PLANNING DEPARTMENT – Development Review Services

RE: Mesa Del Sol Neighborhood - Montage Units 3 & 4 (File: R16D006)
Drainage Report, Engineer's Stamp Date 4-25-2014
Grading and Drainage Plan, Engineer's Stamp Date XXXXX

Based upon the information provided in your submittal received 8-29-14, the above referenced Drainage Report and G&D Plan cannot be approved for Grading Permit until the following comments are addressed:

EXISTING CONDITIONS BASIN MAP

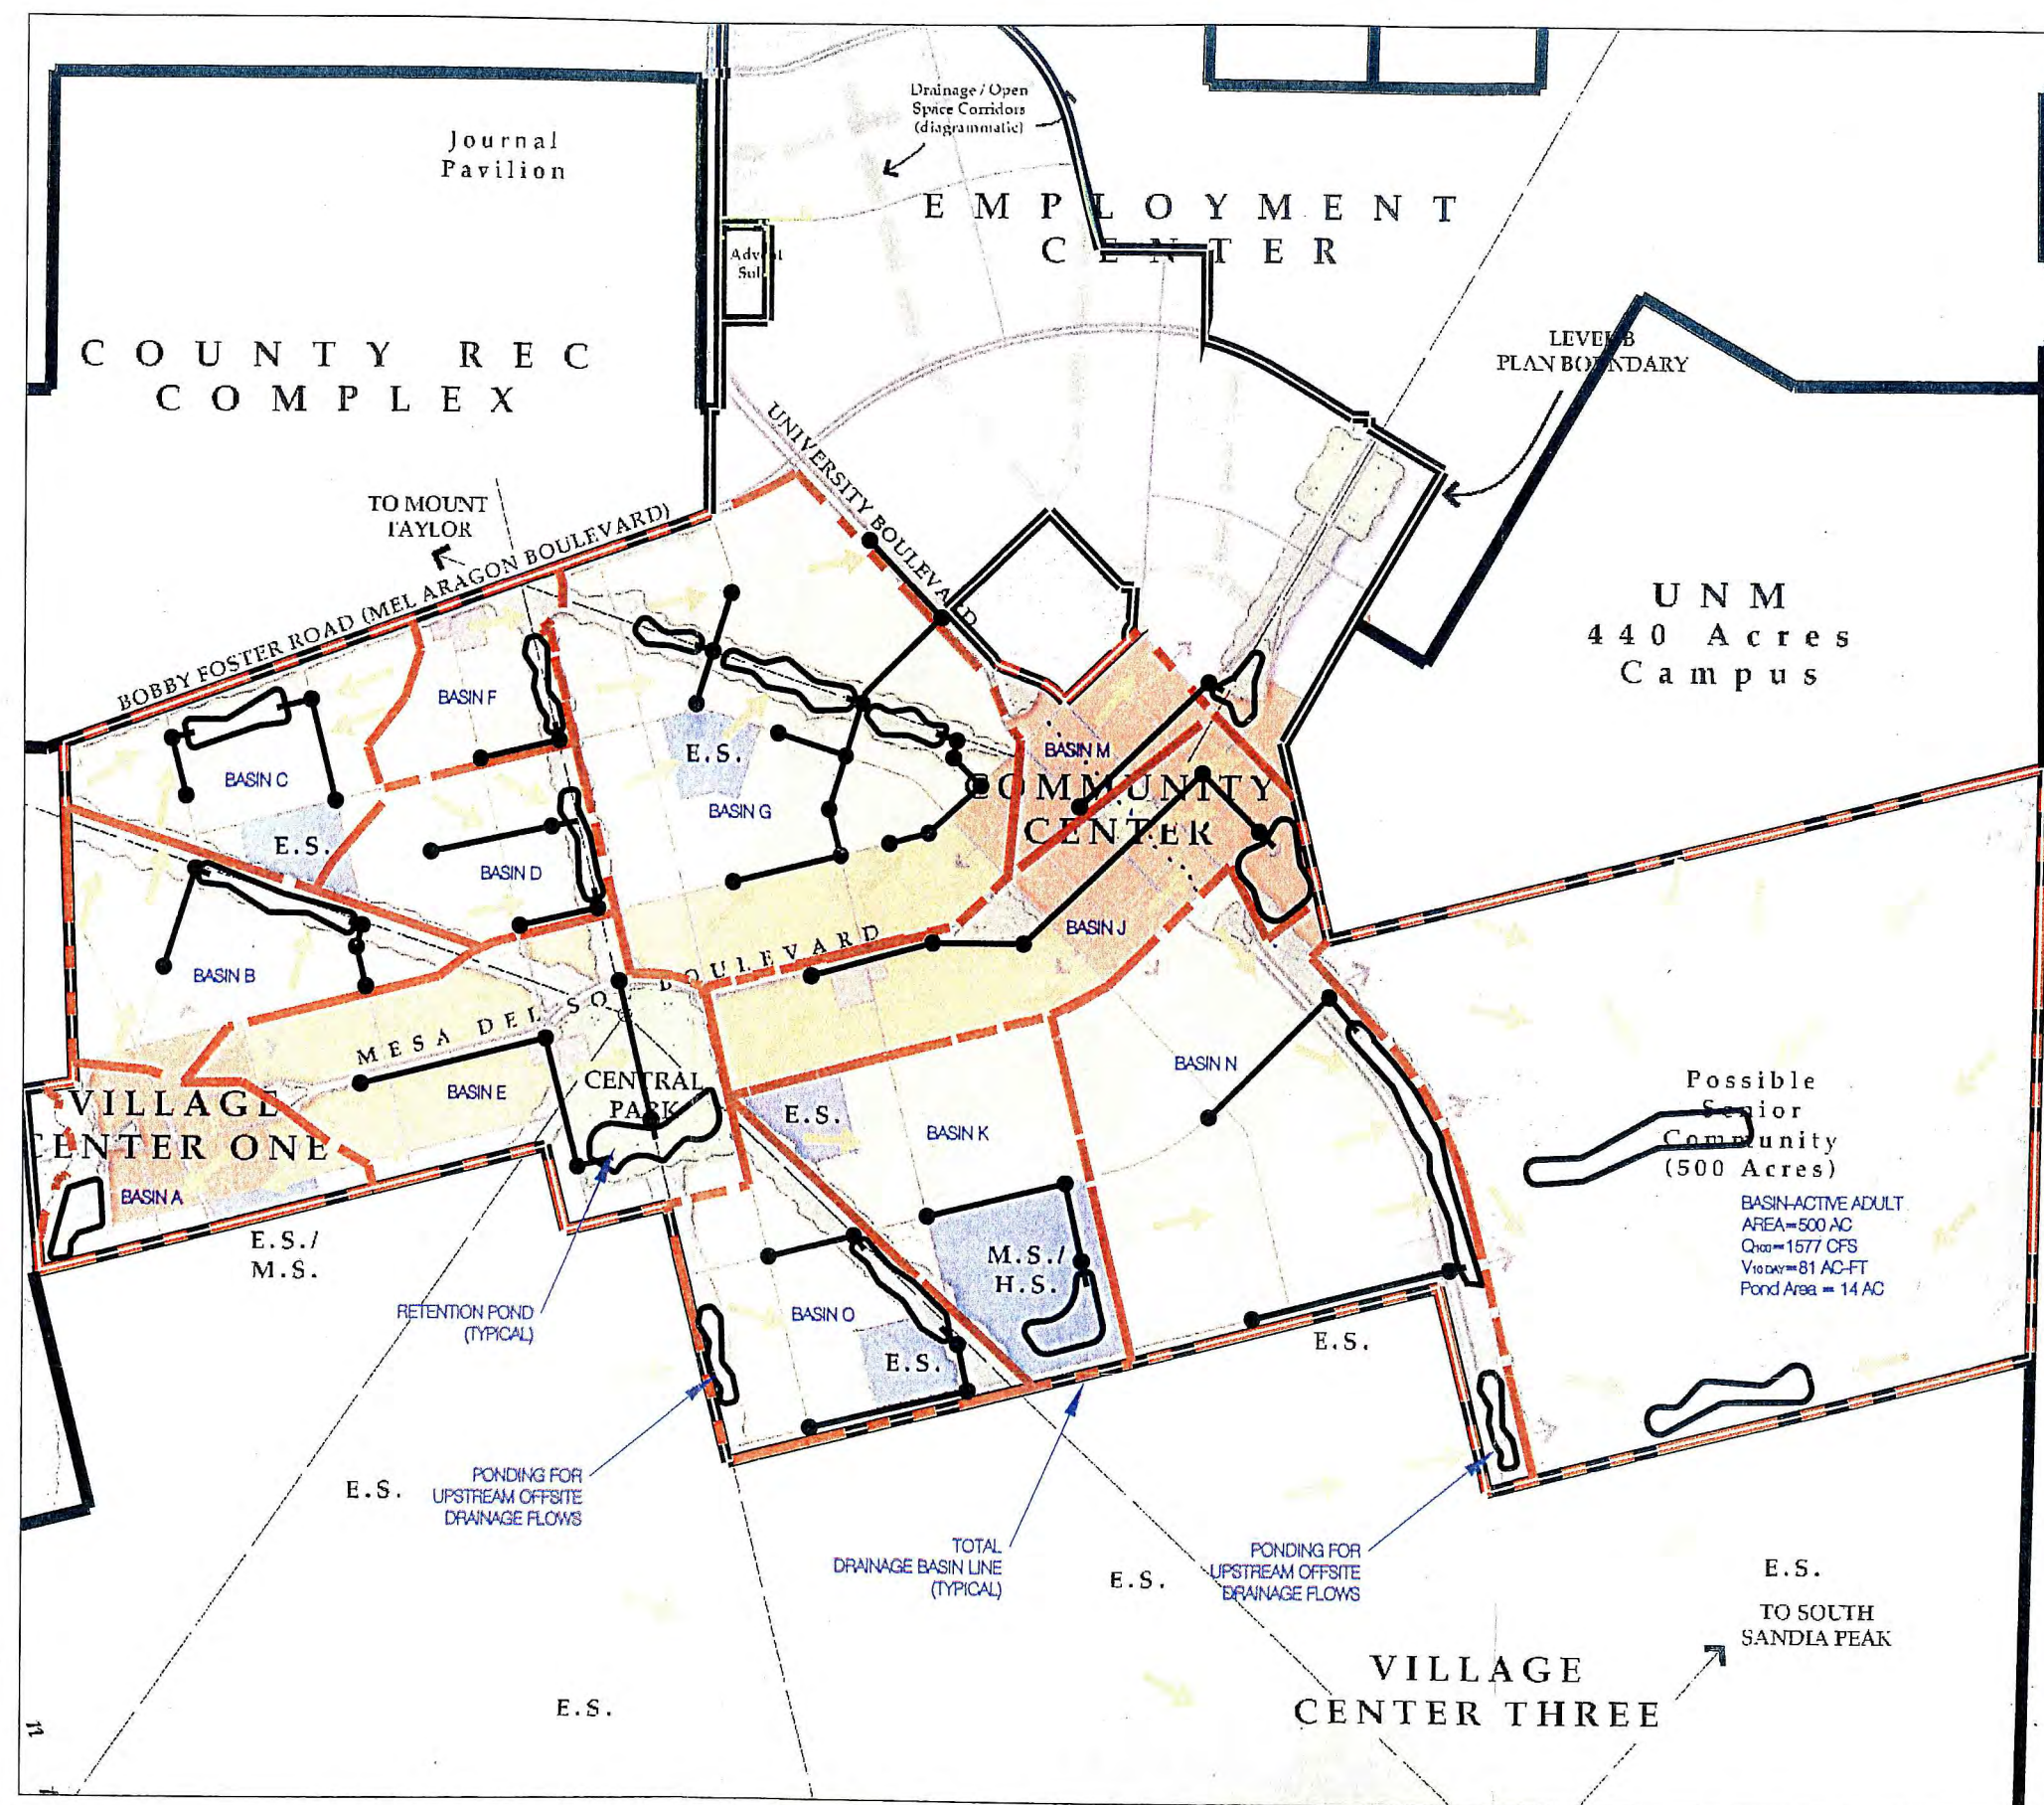
4. While I understand that flows from Future Basins 1, 2, and 4 cannot enter the project site due to the 2-ft to 3-ft grade difference, there needs to be a plan that demonstrates how the runoff is managed in the interim (after Montage 4 is built, but before future development). A blow-up of the Existing Conditions Basin Map with labeled contours should demonstrate how Offsite Basins 1 and 2 drain.

EXHIBIT 9
GRADING PLAN

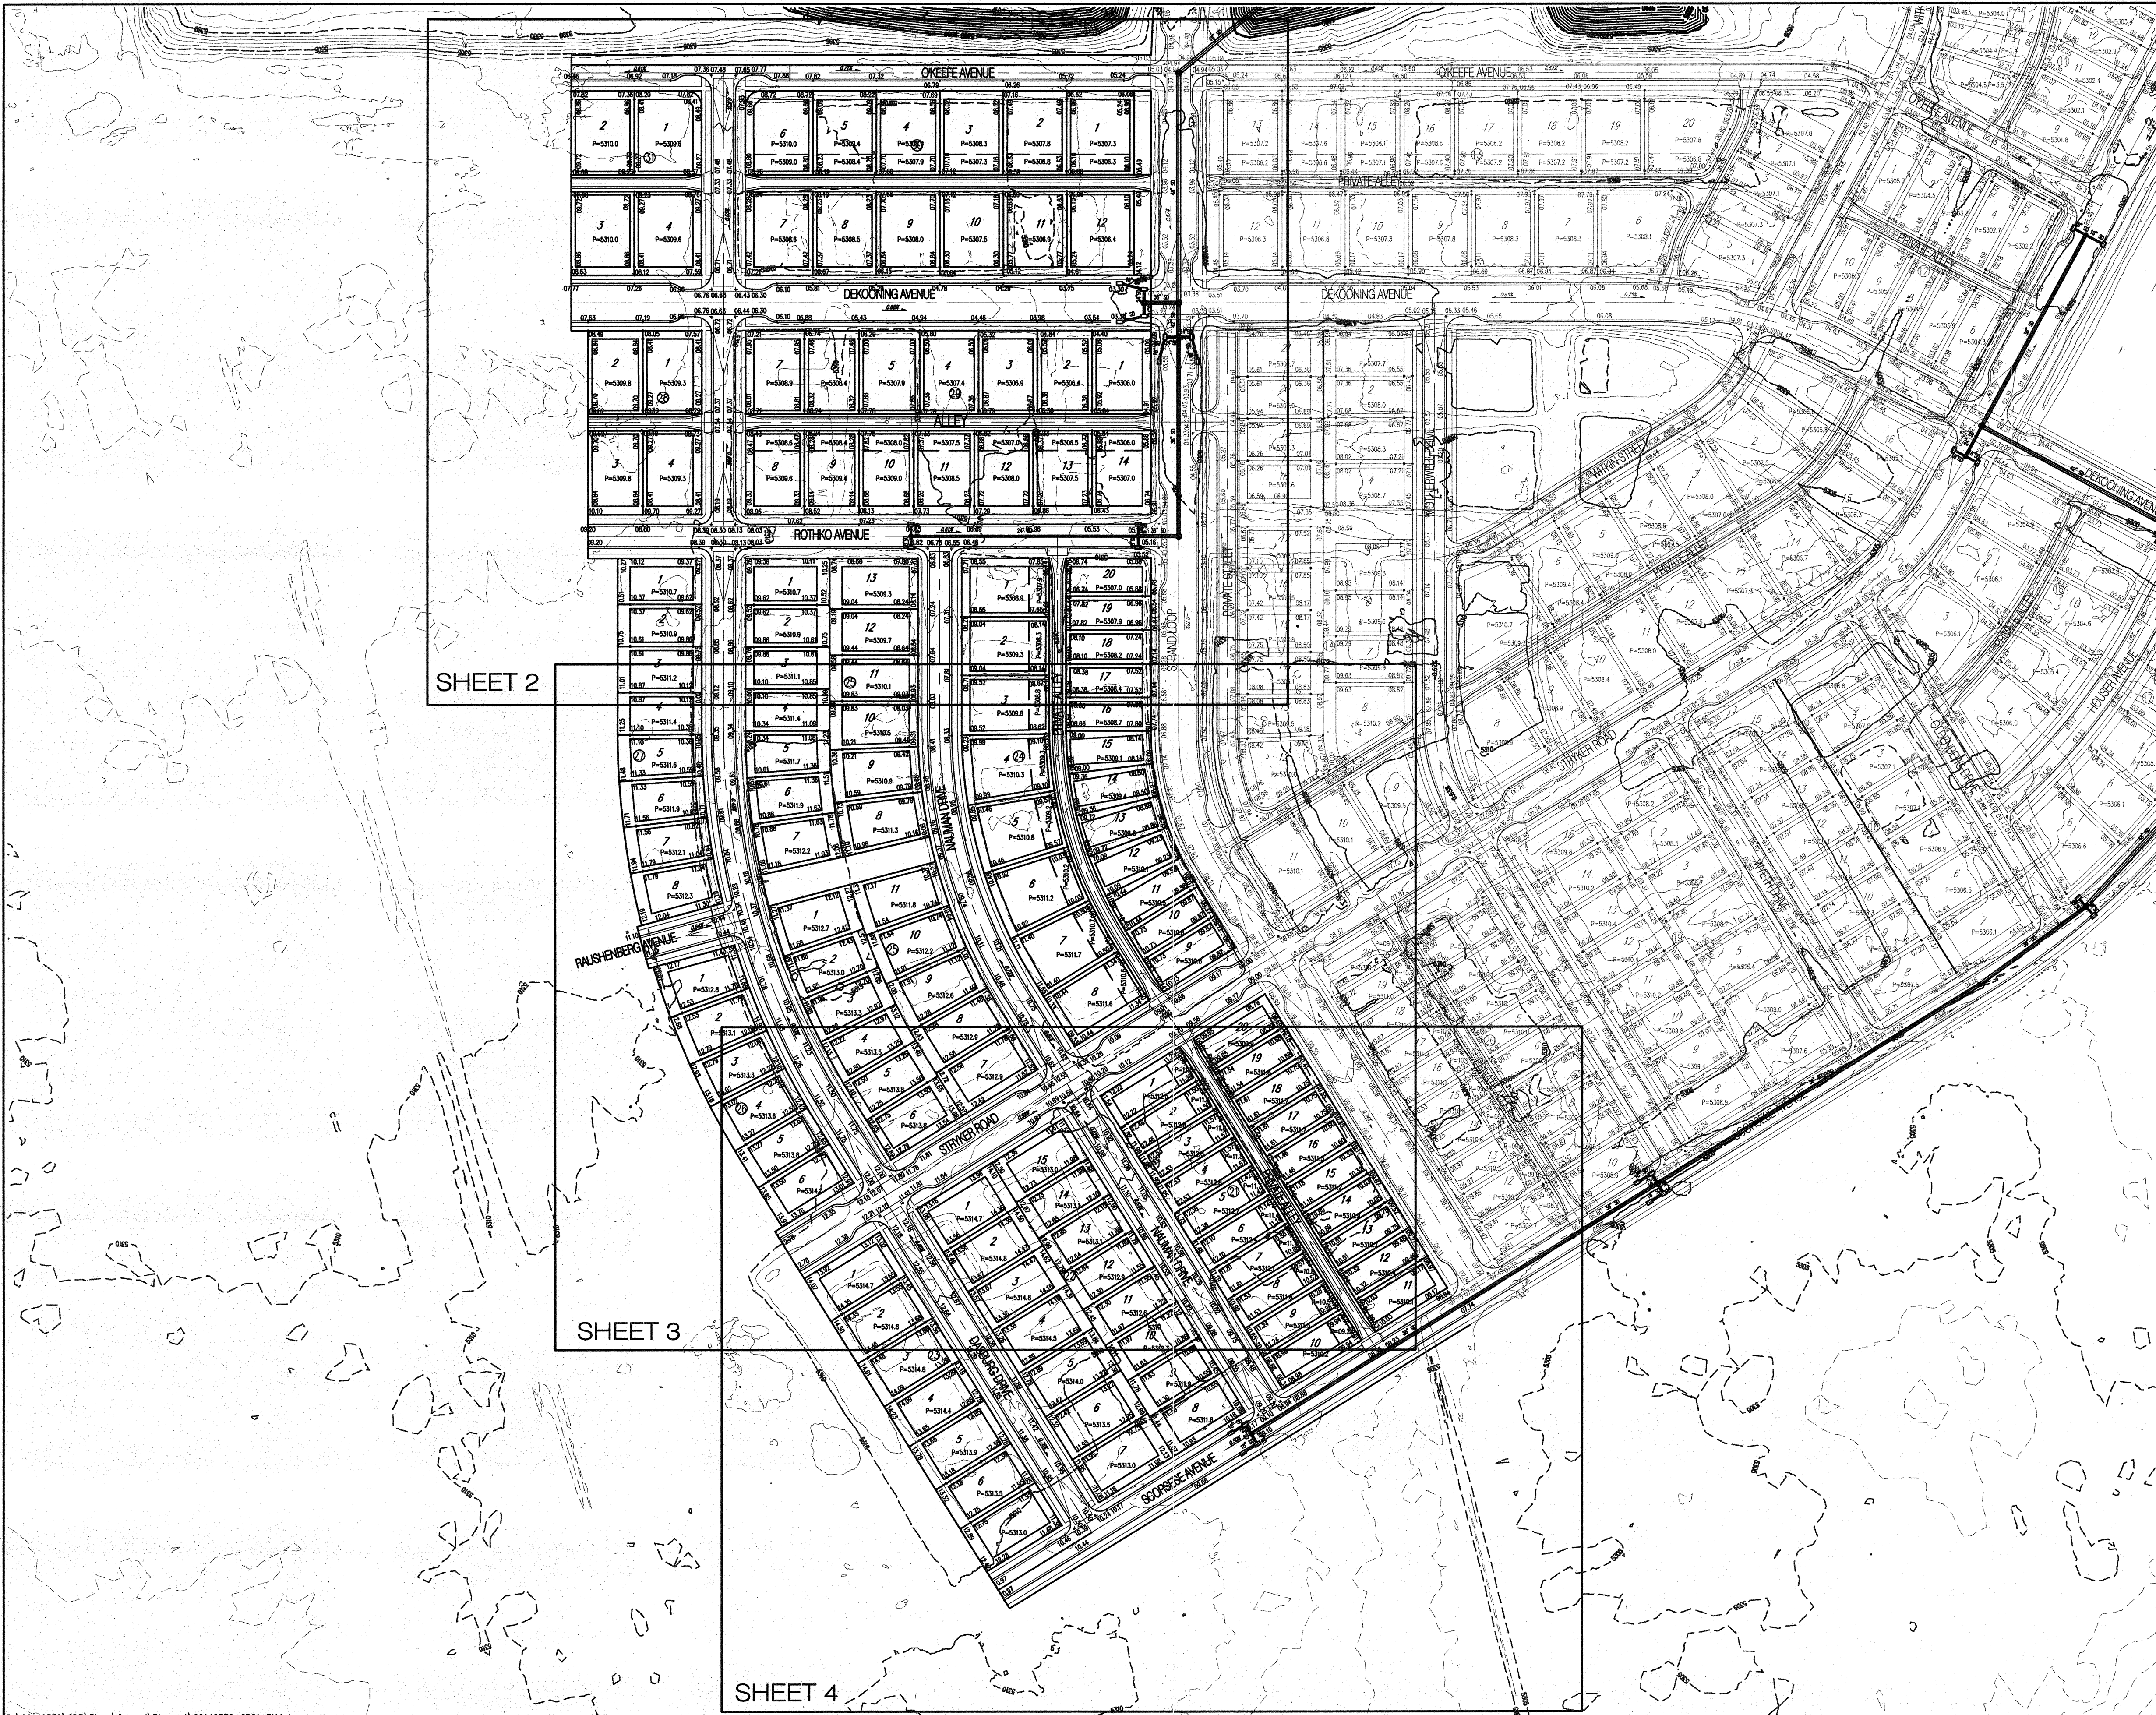
3. The grading plan for Montage 4 should reflect the existing conditions, specifically the present state of the rough grading. Contours along the western boundary of Montage should reflect the 2-ft to 3-ft grade difference
